# CITY OF ALBUQUERQUE

April 24, 2025

**RE: 2500 Phoenix Ave. NE**  
**Menaul & Vasser**  
**Grading & Drainage Plan**  
**Engineer's Stamp Date: 01/03/2025**  
**Hydrology File: H16D156**  
**ABQ-PLAN File: HYDR-2025-00060**

DRAWN BY: JLT
 DATE: 08/21/2025
 DRAWING
 SHEET #: C2.0
 JOB #: 2022093

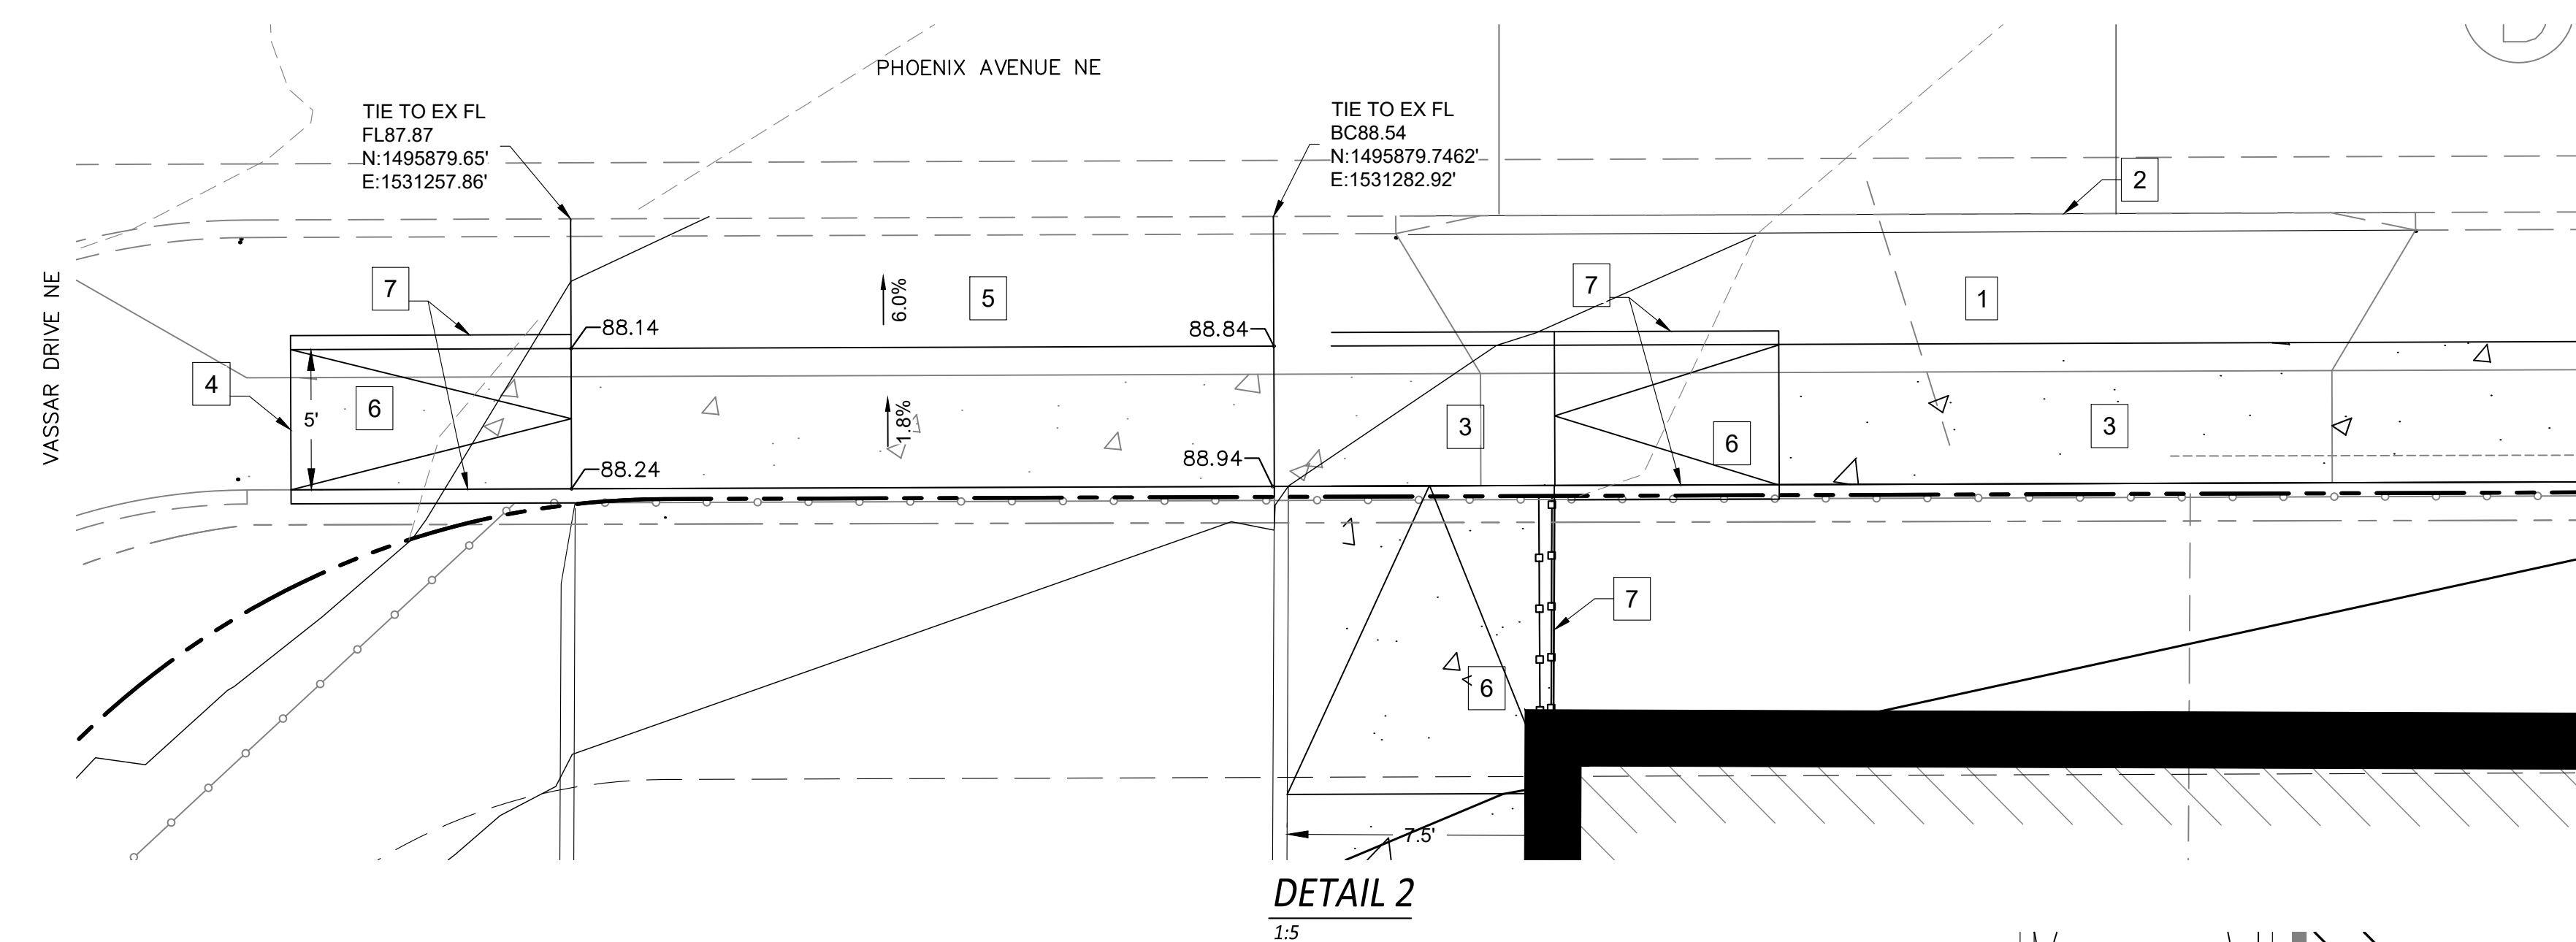
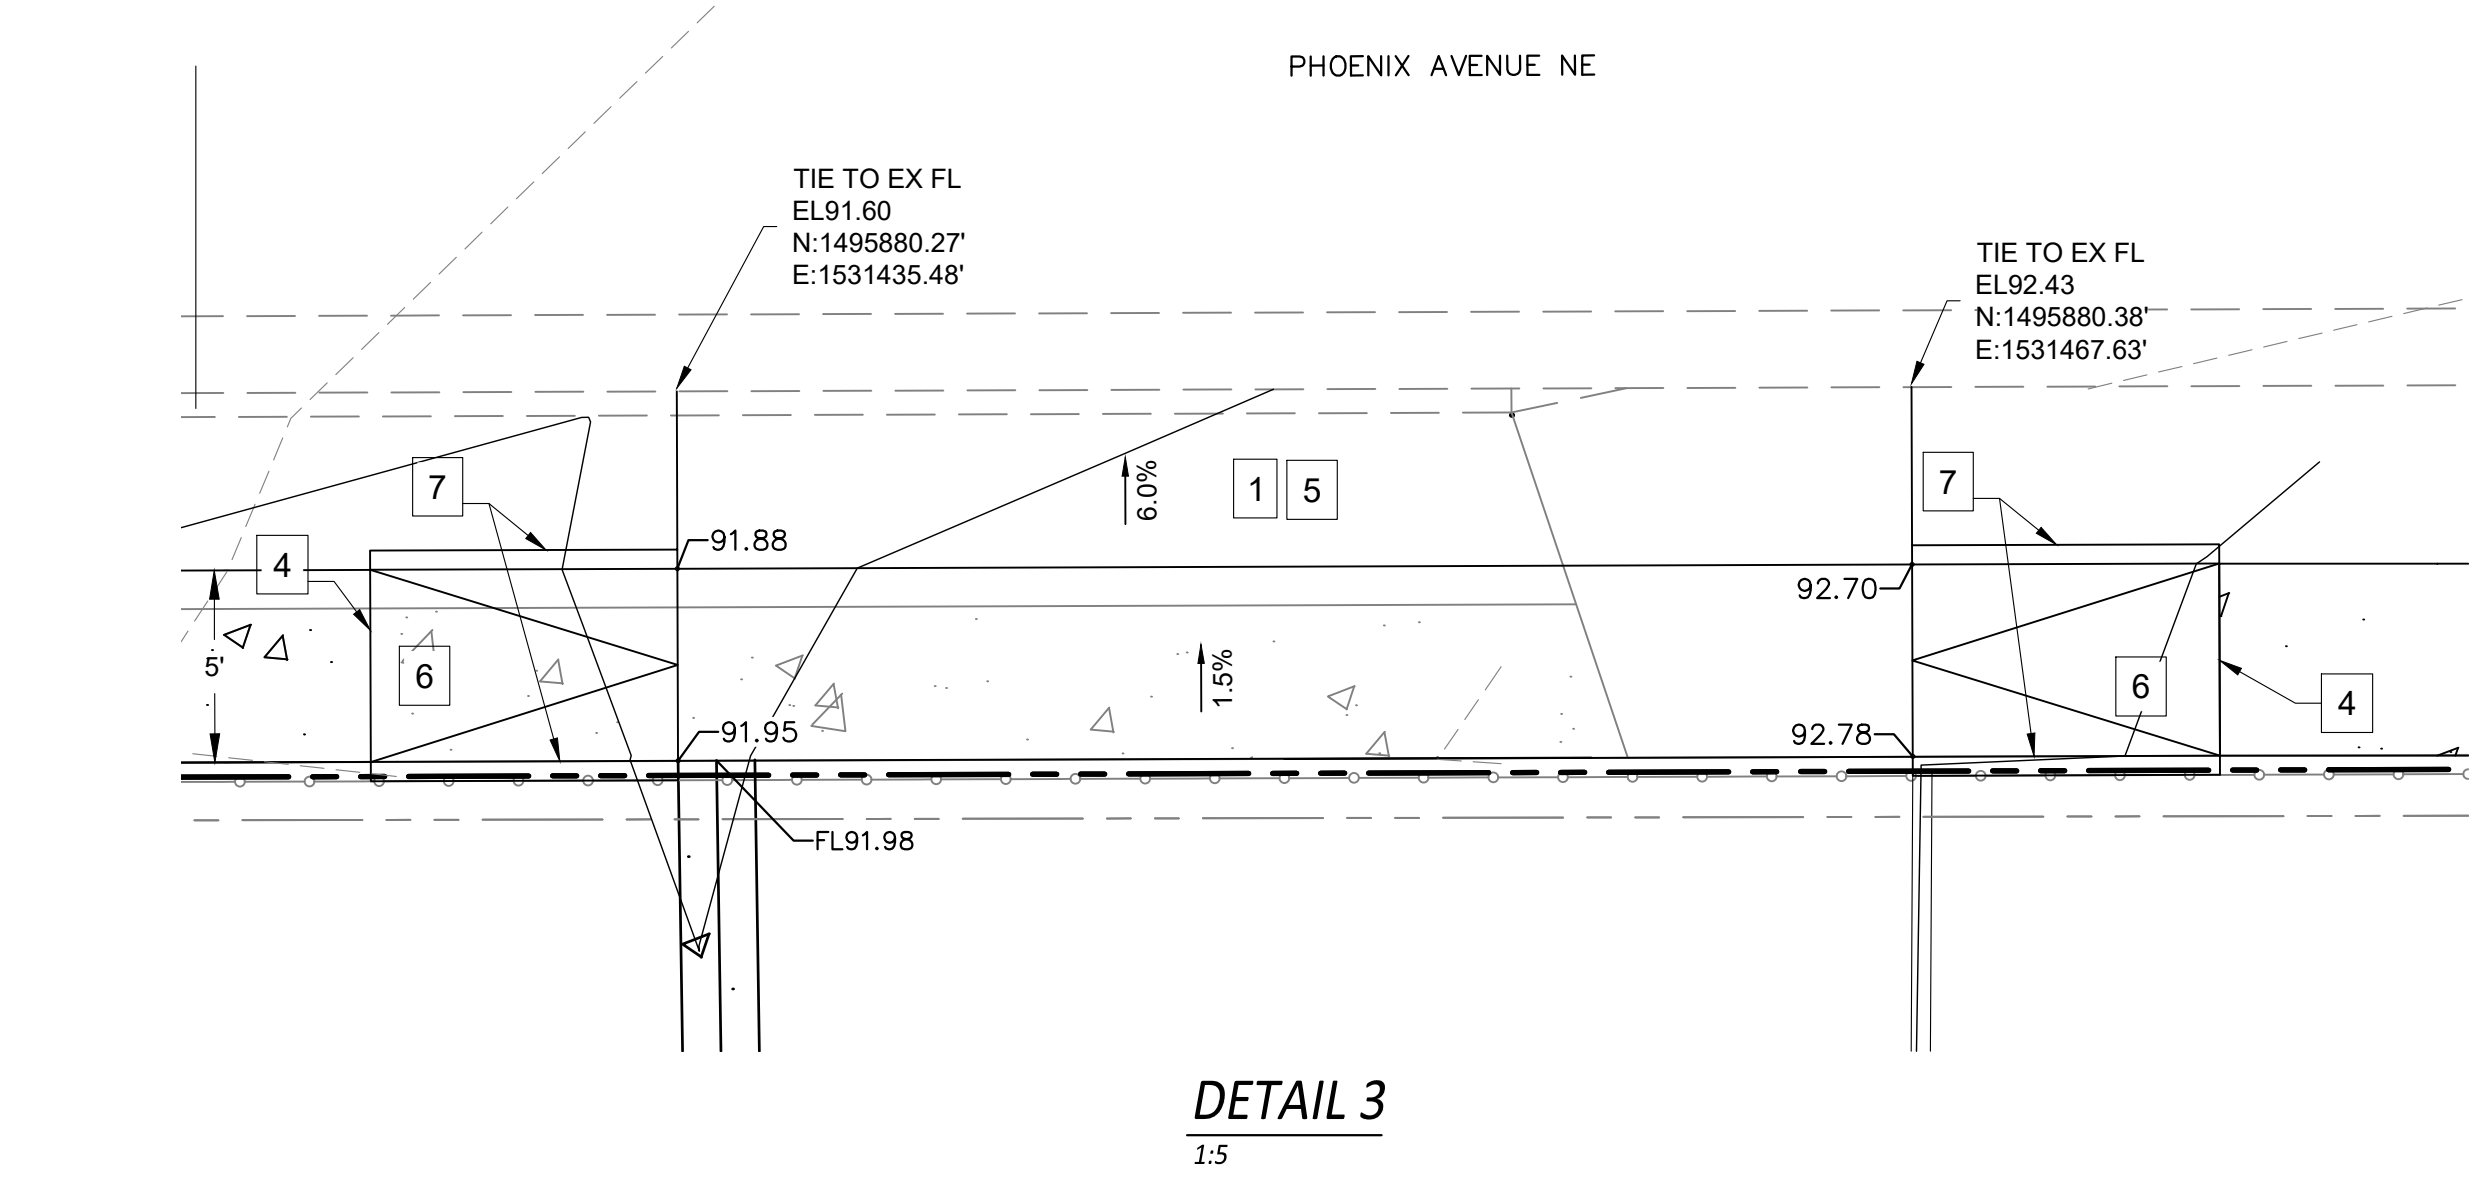
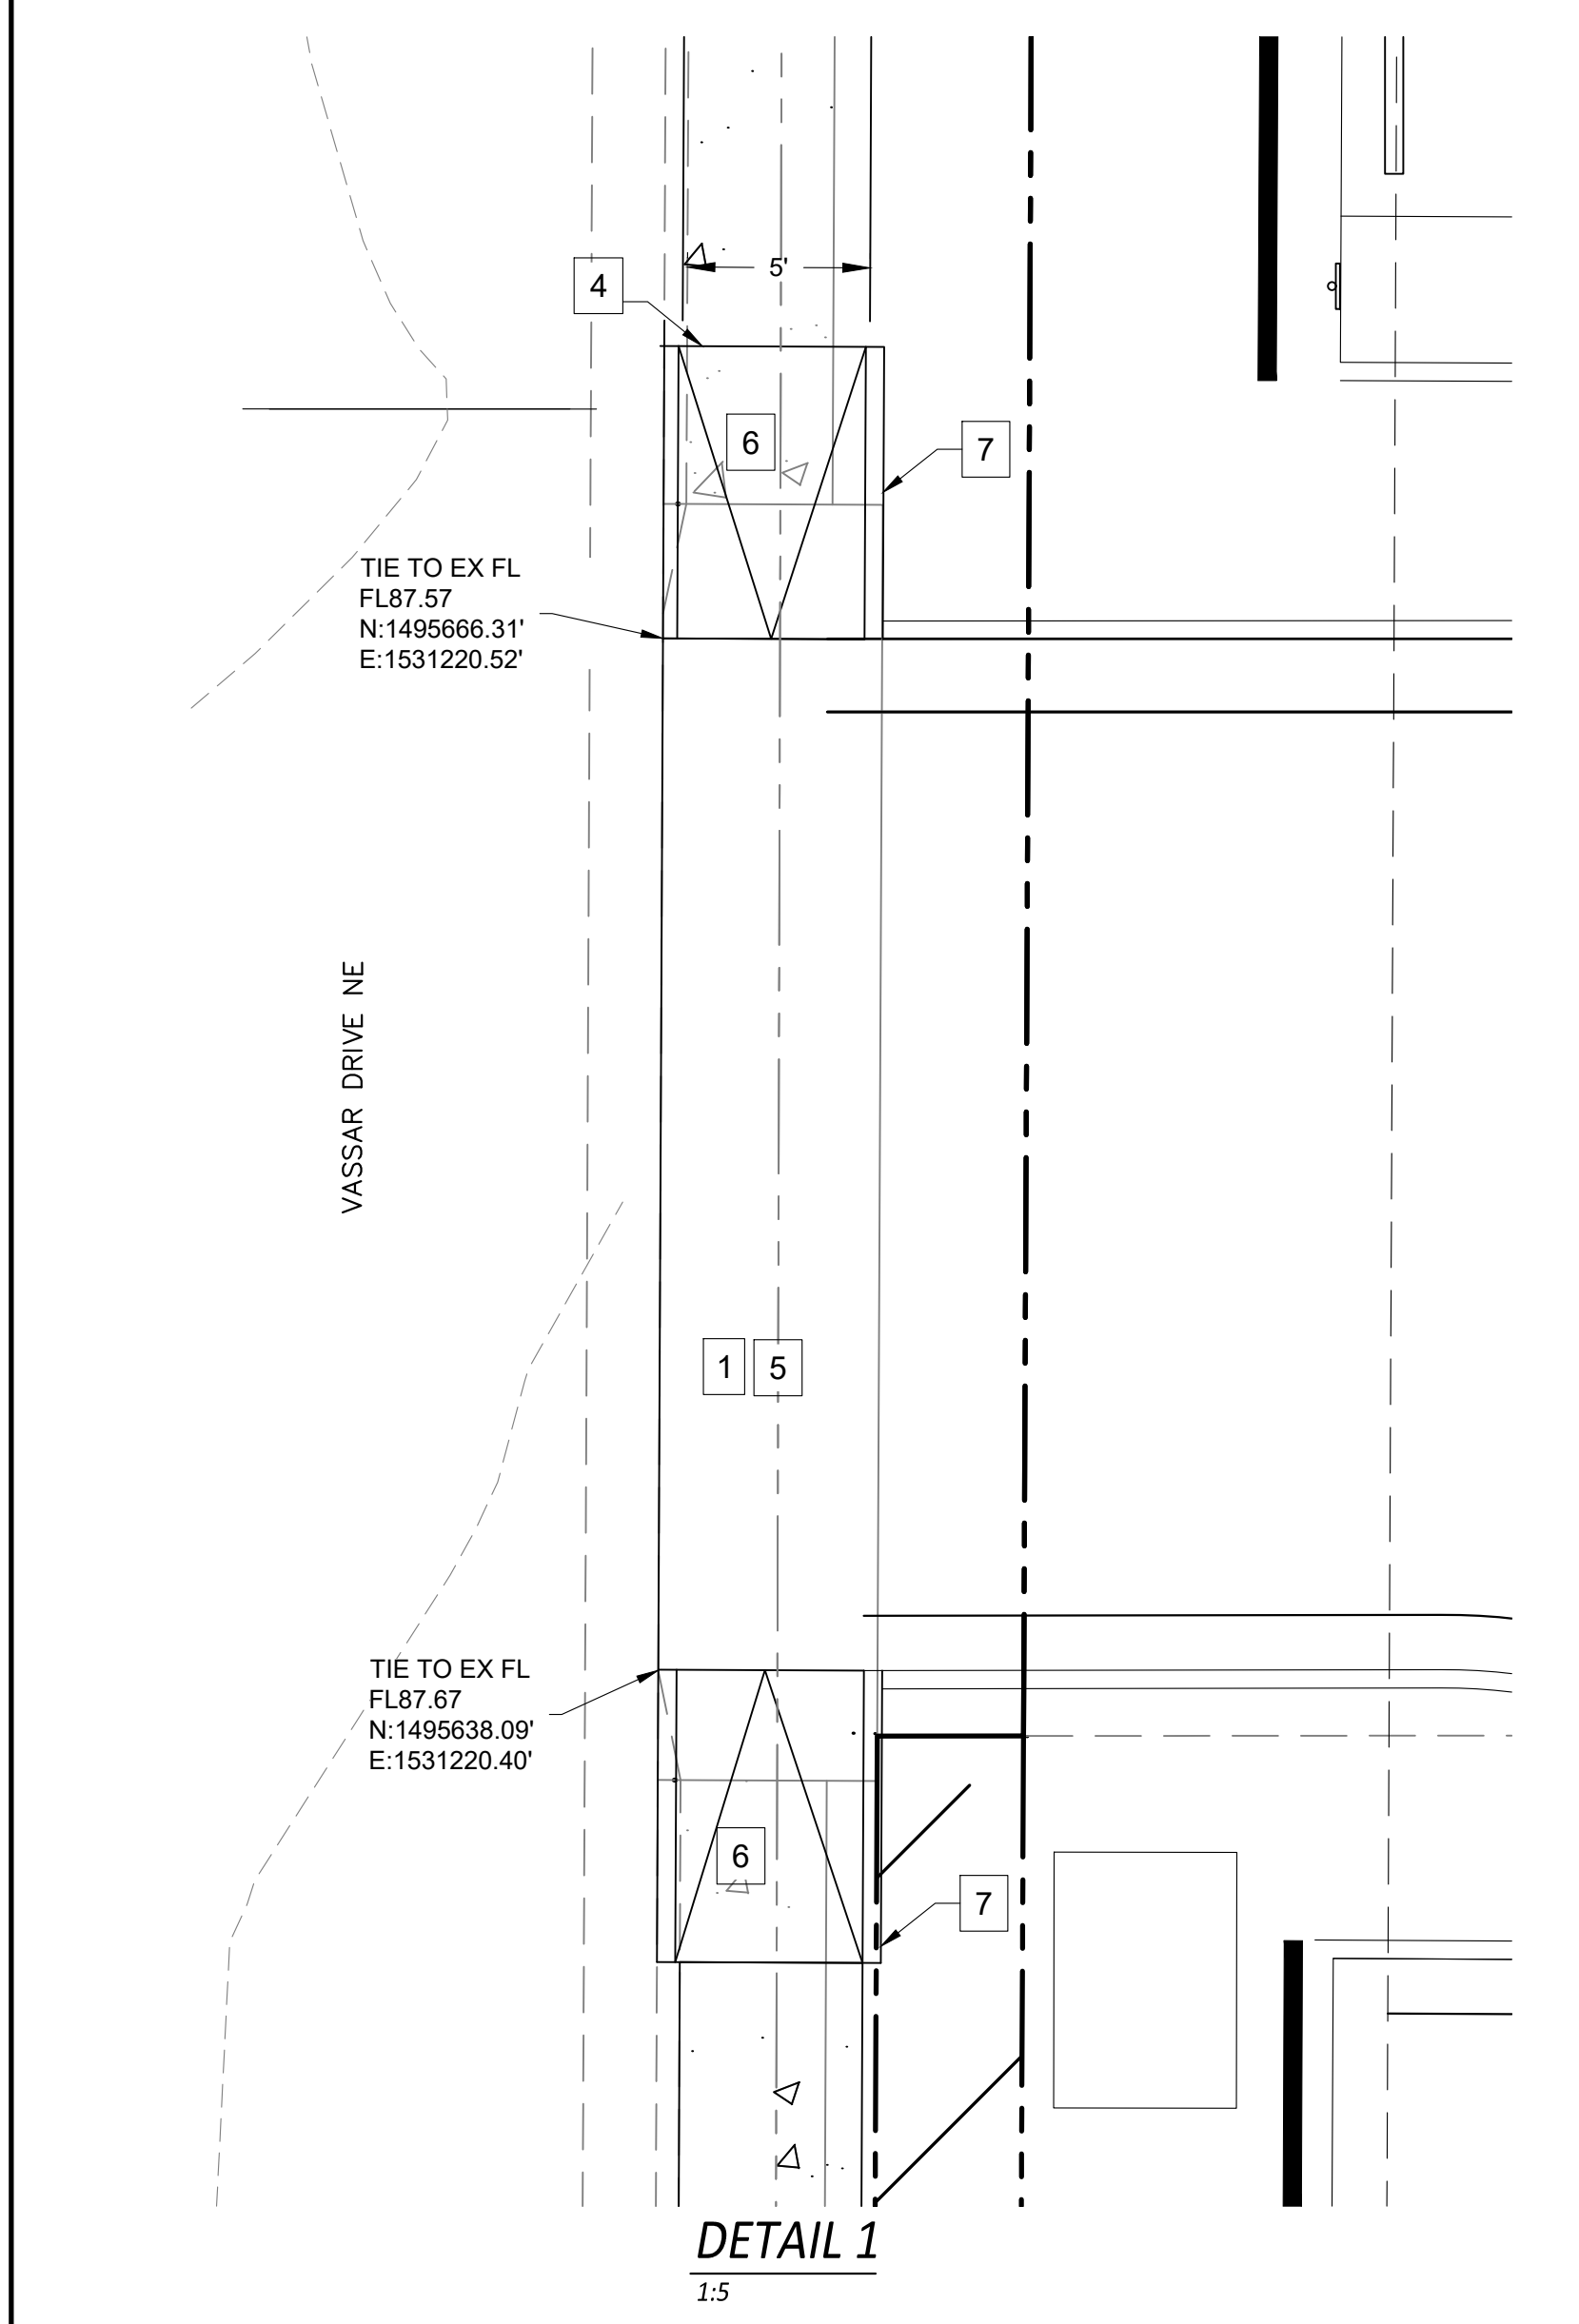
1. Revisions to Grading & Drainage Plans (G&D Plans) require a **current** Engineer's stamp and date. Revisions and corrections were made to the G&D Plans per the response letter dated April 2, 2025, yet the Engineer's stamp date is still 01/03/2025, and not acceptable.
2. From previous Comment No. 8 (CABQ Hydrology review of 03/11/2025): Sheet C2.0: From field observations, the existing 30' Private Access and Drainage Easement appears to be providing access to the property/parcel/business to the east of this project which would be adversely affected by the proposed retaining wall, both for vehicular access and stormwater conveyance.

**Response:** The access for Tract 1-D (the property/parcel/business in question) will divert to entering/exiting from Tract 2 (east of the property/parcel/business in question). This is shown on the grading plan with the callout "Future driveway." The owner for Tract 2 has agreed to the proposed driveway.

Please provide a copy of the agreement from the owner of Tract 2, with acknowledgment of the stormwater impacts to property if drainage easement to the west is vacated or abandoned.
